CITY OF ALBUQUERQUE

October 28, 2016

**RE: State Employees Federal Credit Union
Grading and Drainage Plan
Engineer's Stamp Date 10-19-16 (File: F16D001)**

ENGINEER'S SEAL DAVID SOULE 10-19-16	STATE EMPLOYEE FEDERAL CREDIT UNION GRADING AND DRAINAGE PLAN Rio Grande Engineering 1606 CENTRAL AVENUE SE SUITE 201 ALBUQUERQUE, NM 87106 (505) 872-0999	DRAWN BY WCWJ DATE 10-19-16 21628-LAYOUT-8-28-16 SHEET # 4 JOB # 21628
--	---	--

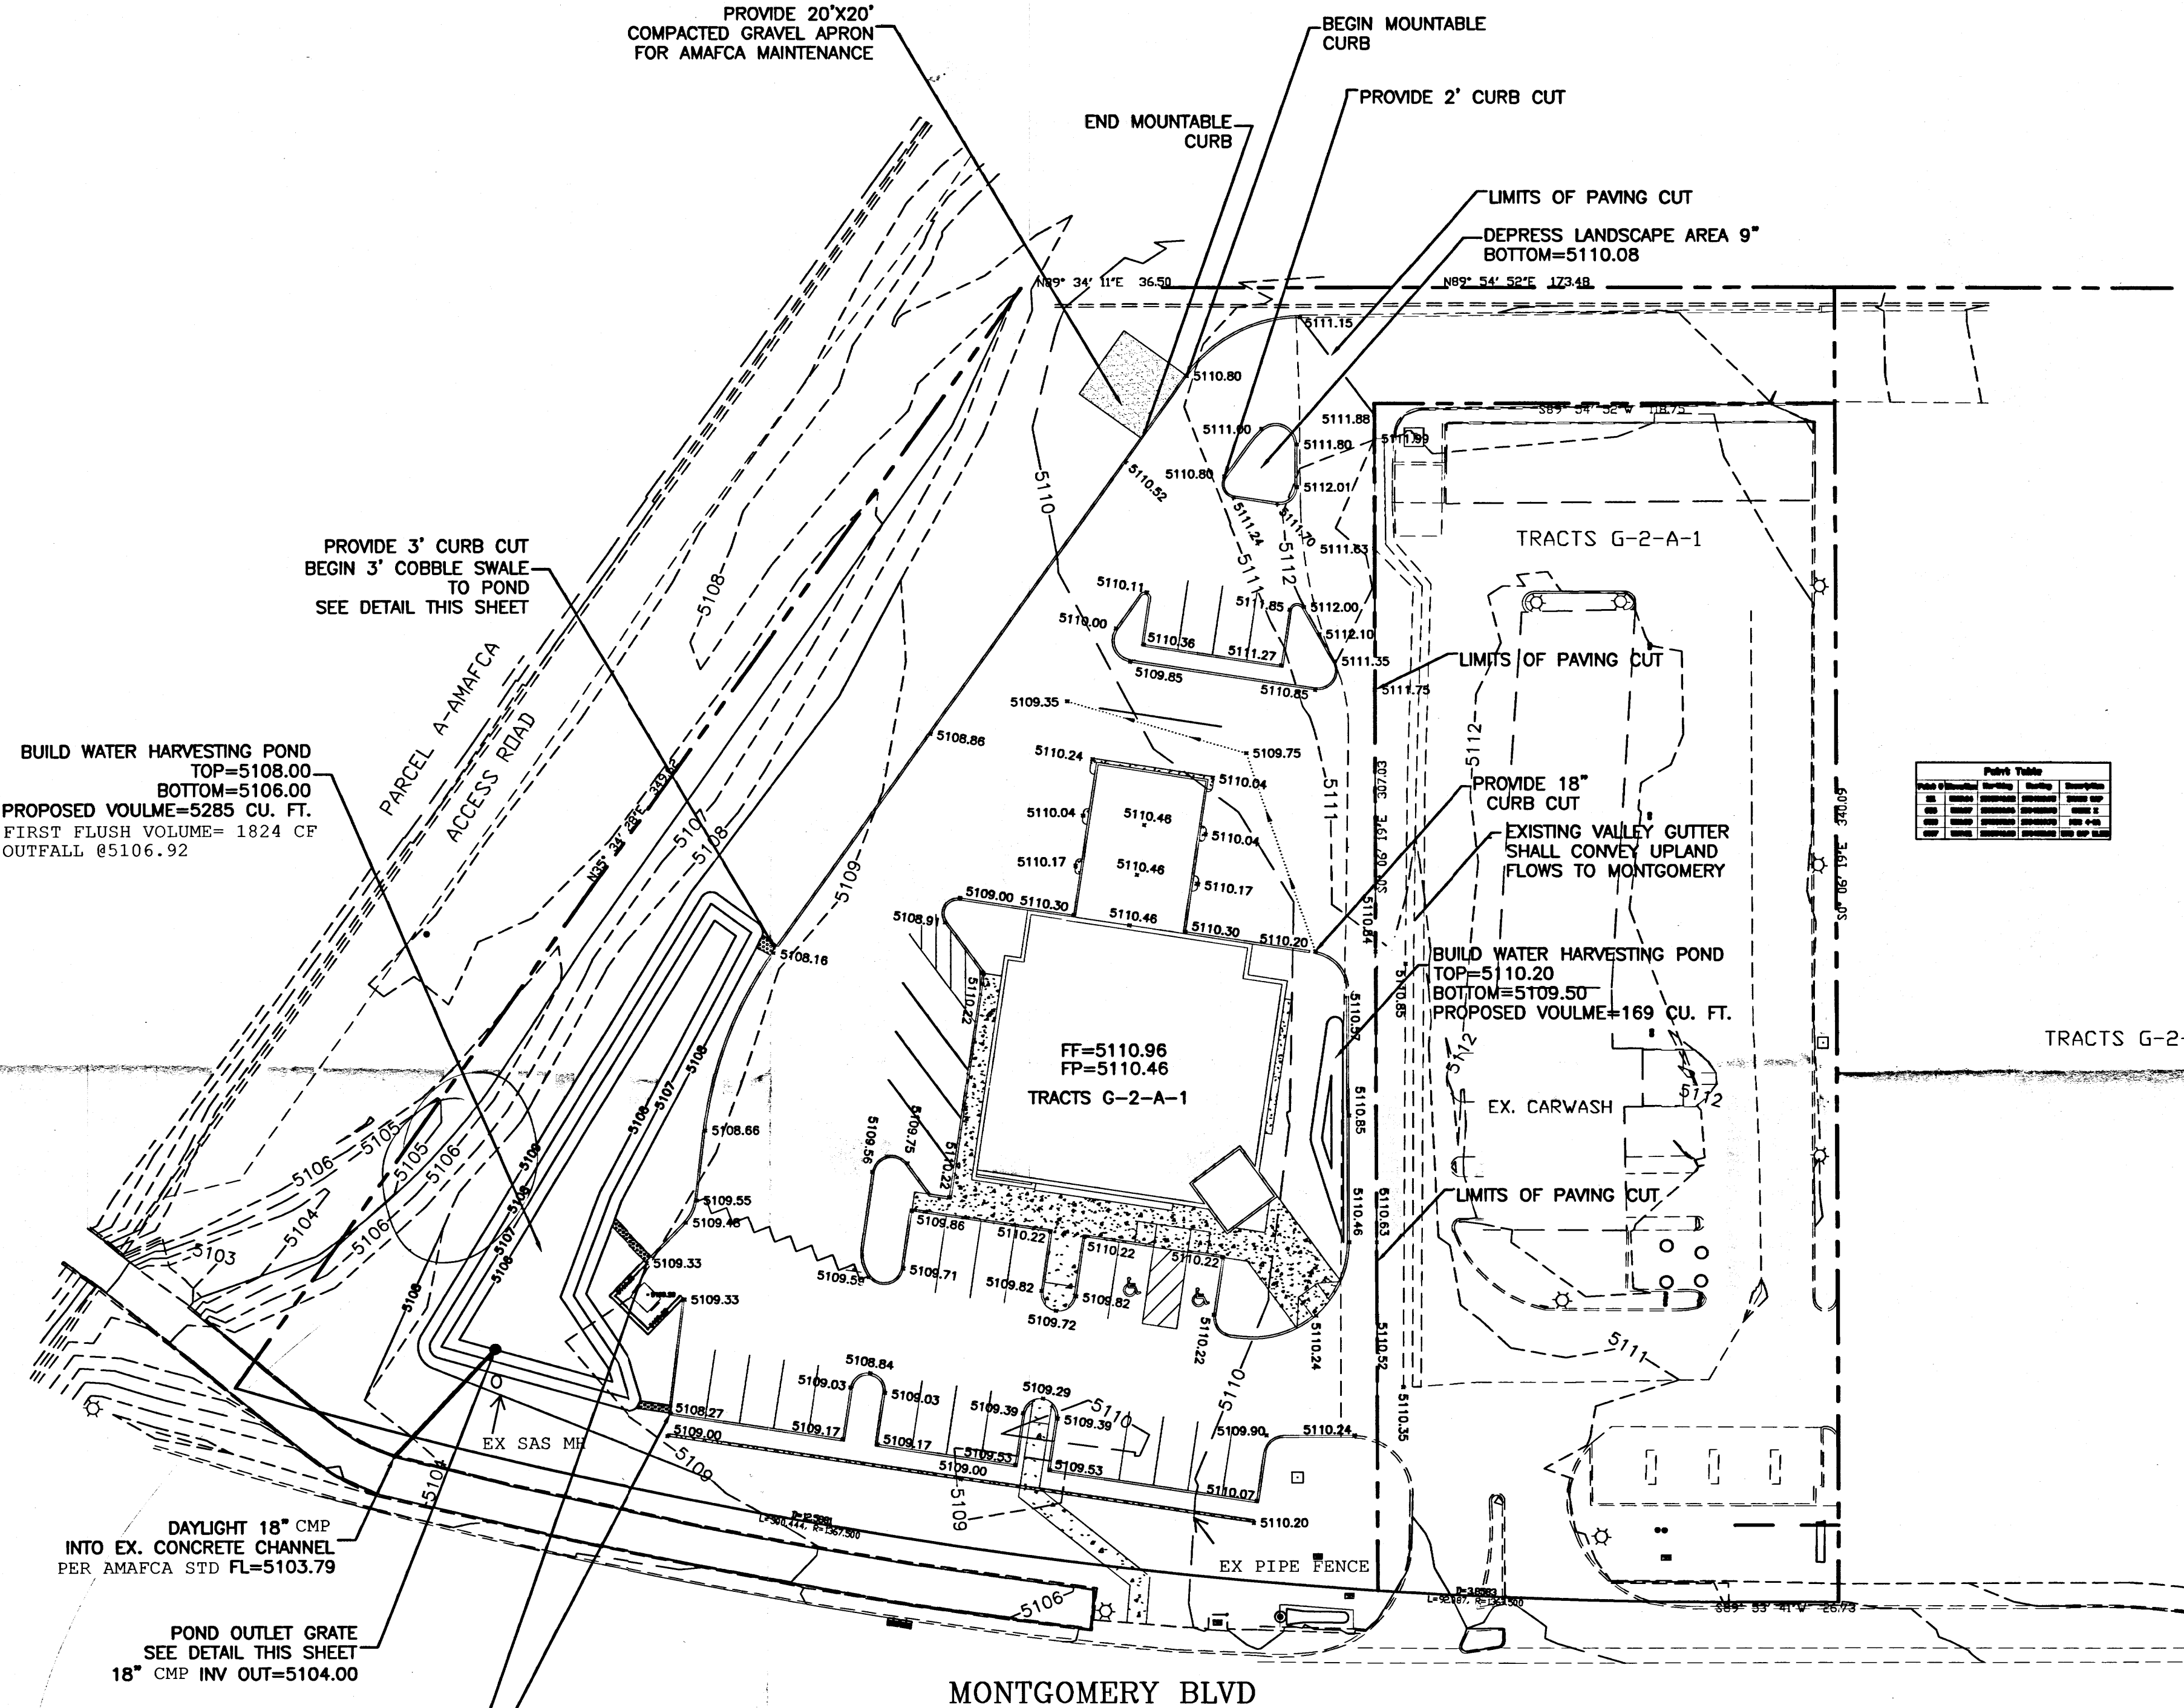
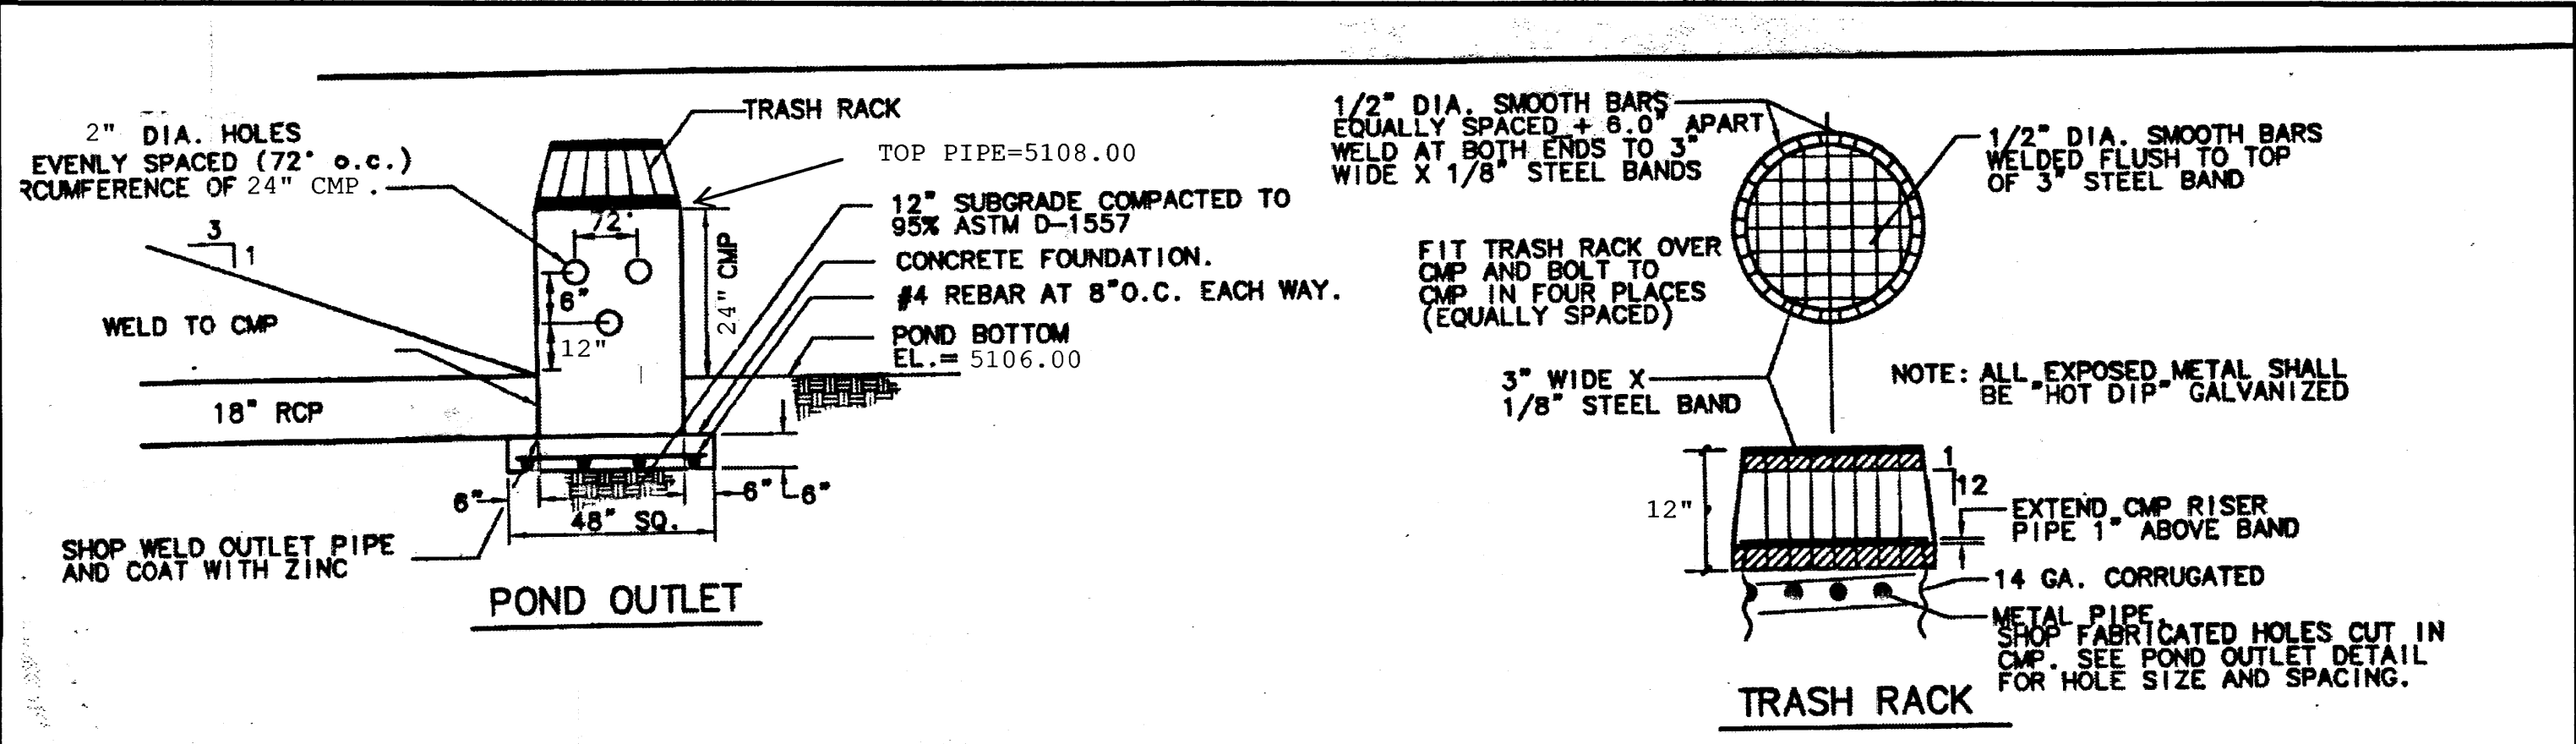
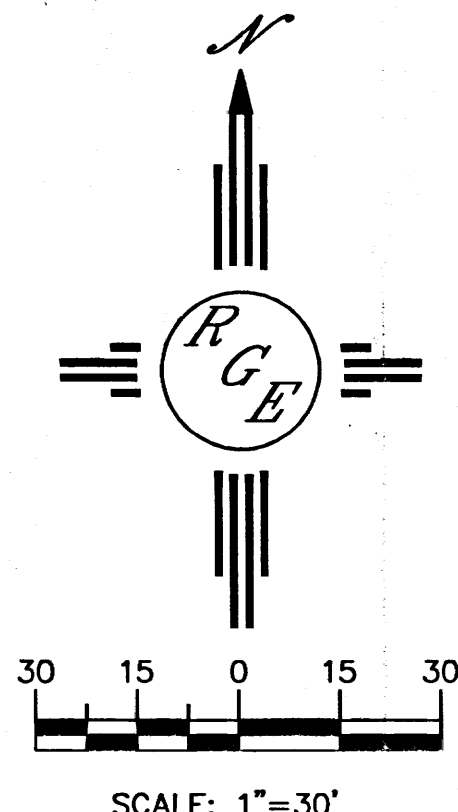
1. The comments from AMAFCA regarding the outfall from the pond into and within their property will be approved through a turnkey agreement. The constructed improvements will need to be approved prior to approval for Occupancy.
2. An approved ESC Plan is secured prior to construction.

I spoke to Jerry Lovato about what AMAFCA would accept in its easement. The manhole and RCP pipe penetration to the Montgomery side channel is the preferred option. But if that is cost prohibitive, we will accept a riprap rundown that will connect to the top of channel. The flowline of the riprap swale will have to connect to the top of channel, so you will have to provide a gently sloped berm to build up the sides of the swale. See attached modified rundown detail for riprap that will replace the dumped riprap detail that I sent previously. Remember that it must be traversable by AMAFCA maintenance vehicles. The riprap rundown in the 15-foot AMAFCA easement will be maintained by AMAFCA upon approval of a turnkey agreement by the Board of Directors. Please provide a detail and calculations showing the swale capacity for the pond outflow.

You can either have the hooded pipe outlet from the pond or the riprap rundown with debris screen. That is up to the owner. If you use the riprap, it must extend to the edge of the AMAFCA-maintained riprap.

On the revised plan, I don't know what you mean by daylighting the pipe to the concrete side channel. A pipe penetration could be expensive, especially since AMAFCA has a new practice of taking maintenance of private storm drain outfalls into our facilities. This would require a RCP pipe and manhole at the easement line since we won't maintain it from the pond. See attached mark-up. It will also require a turnkey agreement approved by the AMAFCA Board. This would not hold up grading, but the owner is proceeding with some risk.

If the grades work, another option may be to let the pipe outfall to a riprap swale. Attached is a detail from the Valero gas station at Broadway and Rio Bravo. The riprap connects to a concrete rundown.

Rio Grande Engineering has revised the enclosed grading plan to incorporate AMAFCA comments regarding access to the channel as well as the nature of the out fall. We have included an outfall structure preferred by the city. The outfall has been designed to allow for 1824 cubic feet of water quality storage, which exceeds the 1,097 cfs (38,700x.34/12) required.
